Your Ref: OWPC313
Our Ref: EP/61/13/NMA
Please ask for:
Mrs A Gardner

Application for a non-material amendment following a grant of planning permission
EP/21/10 - Regency style ornamental gates added to entrance of development in
addition to ornamental metal railings between brick piers with stone caps & pedestrian
access gate with corresponding access path
Nursery Close Manor Road East Preston

Drawing Title
Entrance gates and railings

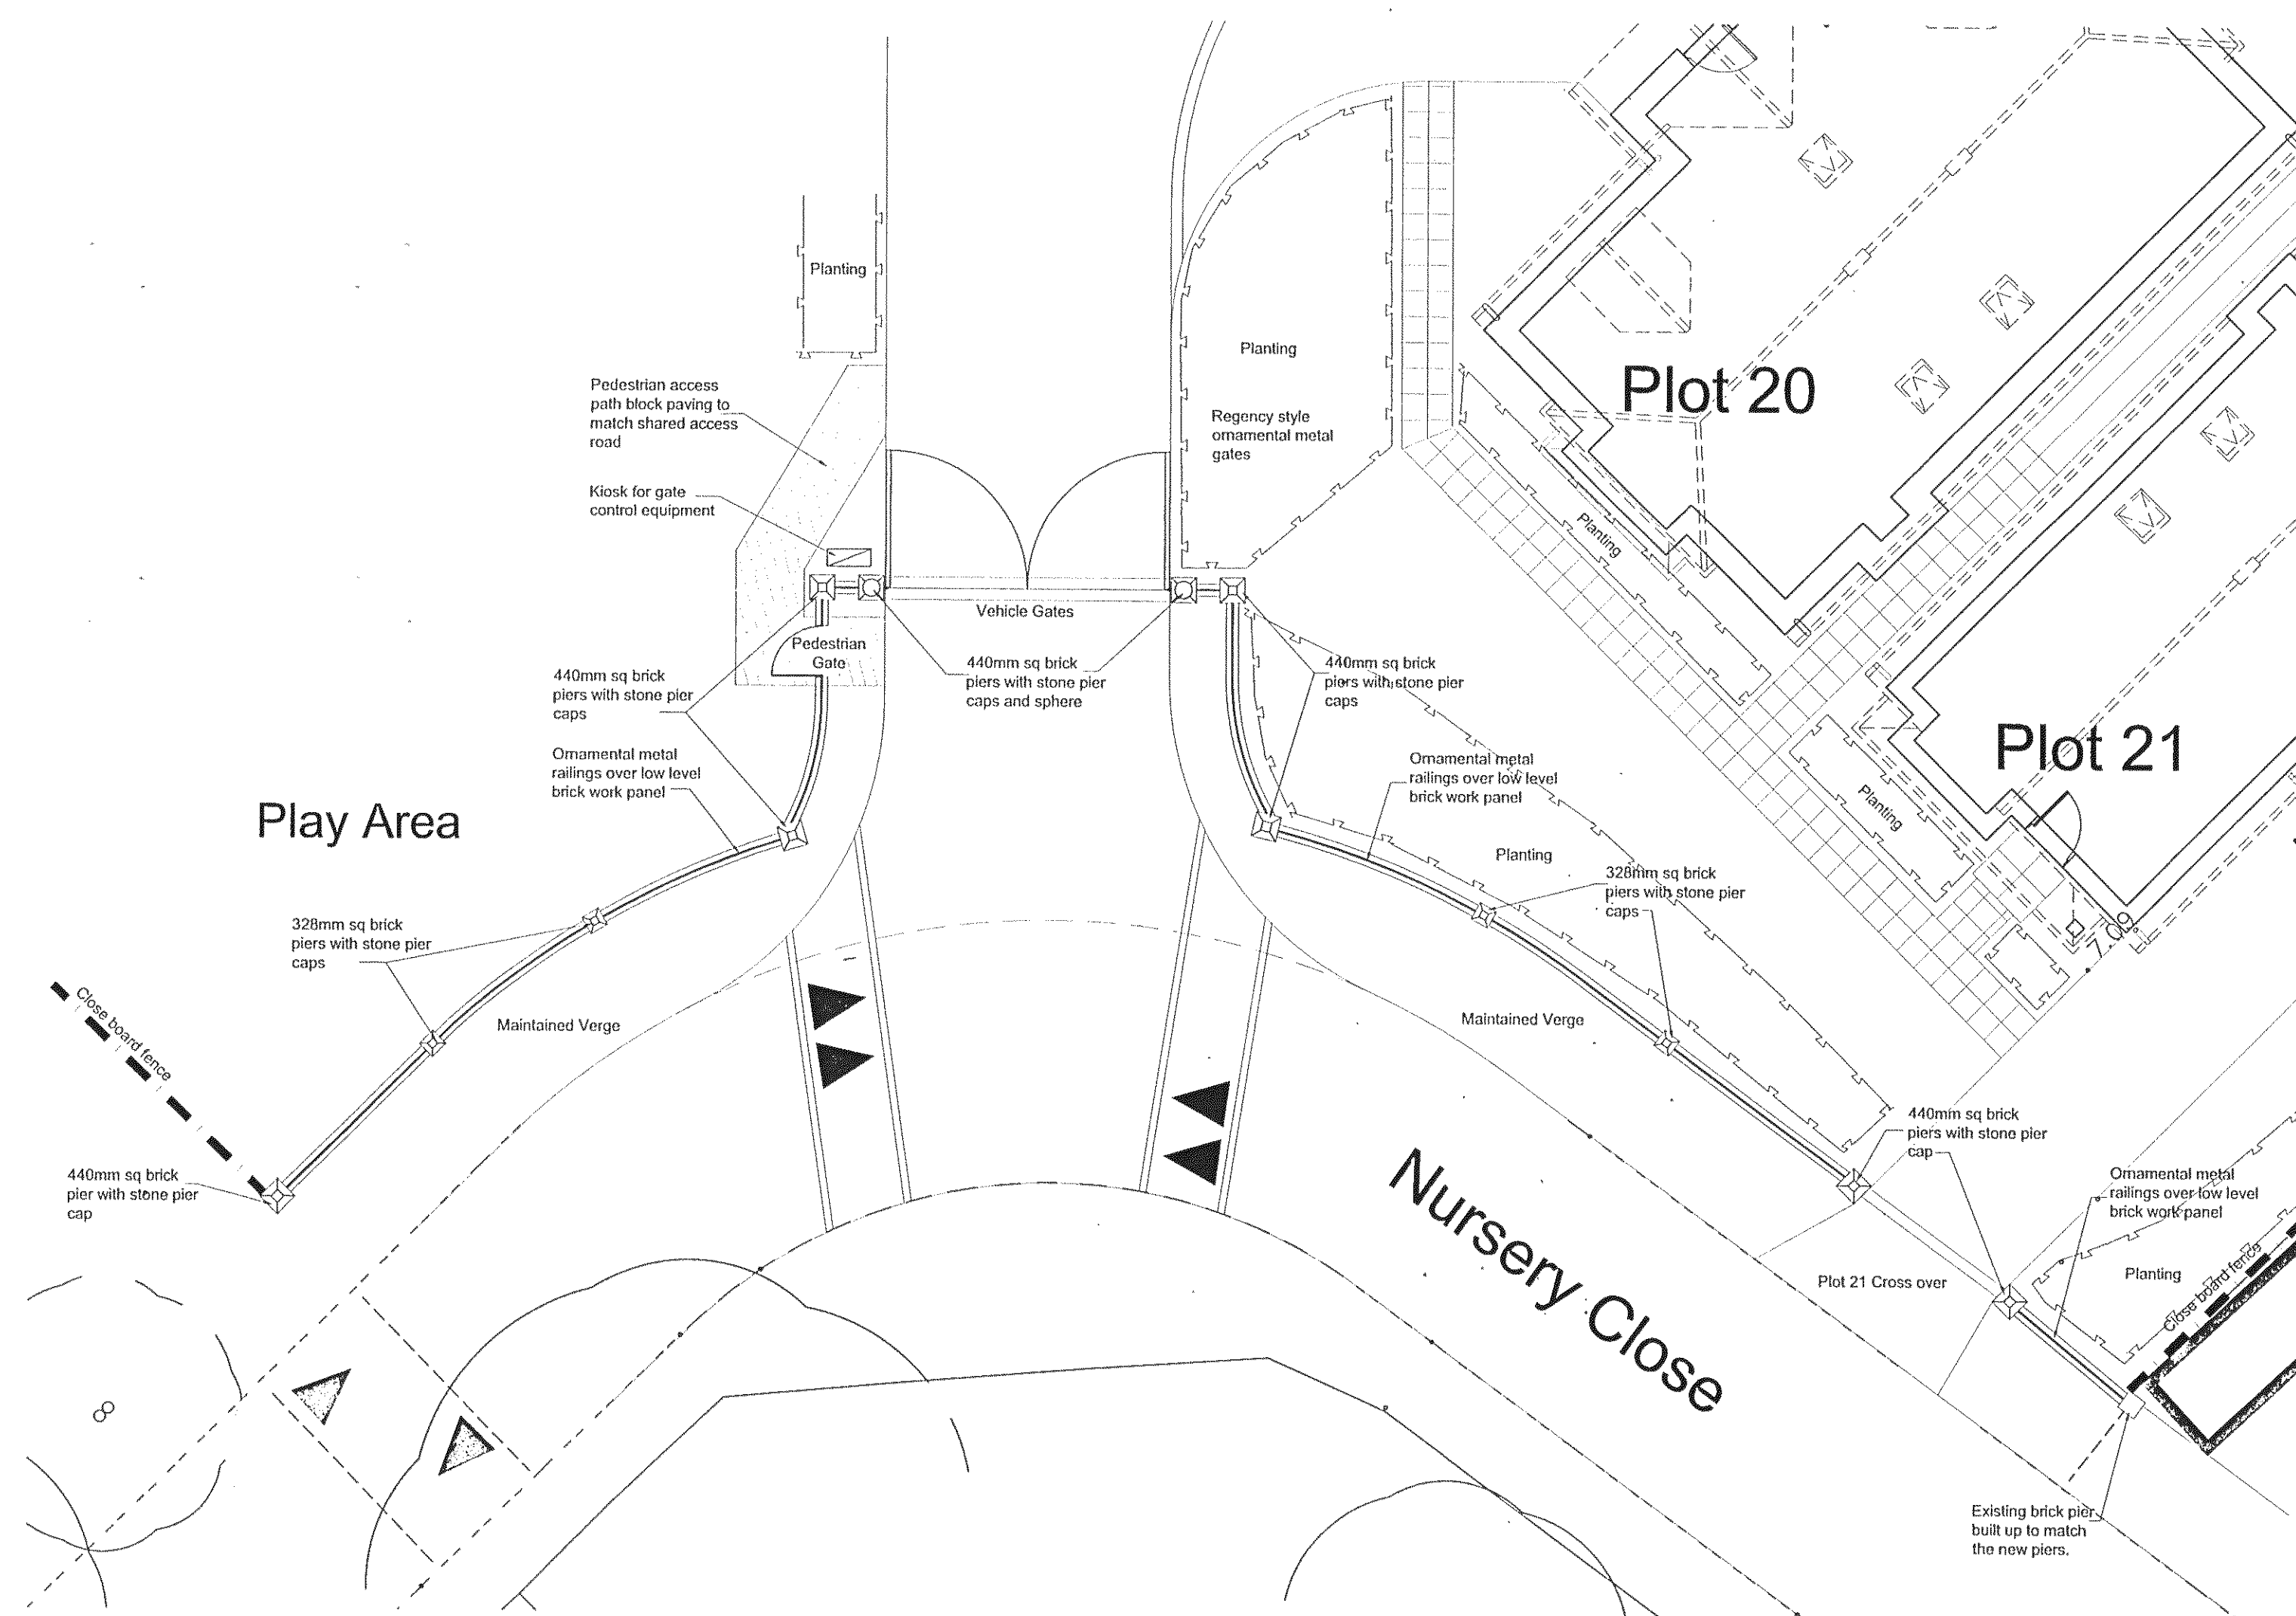
*The proposed gates and railings would out of keeping with the existing street scene in
Nursery Close. Properties in Nursery Close all have a covenant applied that prohibit front
walls more than 2' tall. These gates and railings would have a detrimental impact upon the
appearance of the locality, contrary to GEN7 and DEV19 of the current Arun District Local
Plan.*

*The height of the gates in particular and the railings could be very intimidating for passers-
by. This is contrary to Policy DM17 in the emerging Local Plan which states that
development should "Have minimal impact to users and occupiers of nearby property and
land. For example [-] having an over-bearing presence."*

*The developer's representative has been unable to give definitive confirmation as to
whether pedestrian access will be available to all. Therefore, the council is concerned that
general access to the Local Play Area within Beltane Close will end up restricted, and that
is presumably against the original tenets for including a Local Play Area.*

*The committee is also concerned, that with Nursery Close already being a narrow
thoroughfare, with more than one vehicle waiting to gain access to Beltane Close, it would
not take long for access to and egress from the main part of Nursery Close to be blocked.
If two delivery vehicles happen to be waiting for access at the same time, then Manor*

Road could also become blocked. Further concern was expressed as to how easily a delivery vehicle that has not been able to gain access would be able to turn around to head away again.

For these reasons East Preston Parish Council asks that Arun District Council does not approve this Planning Application, and asks that the developer returns to the original scheme of a low wall at the front of the development as per all promotional material.
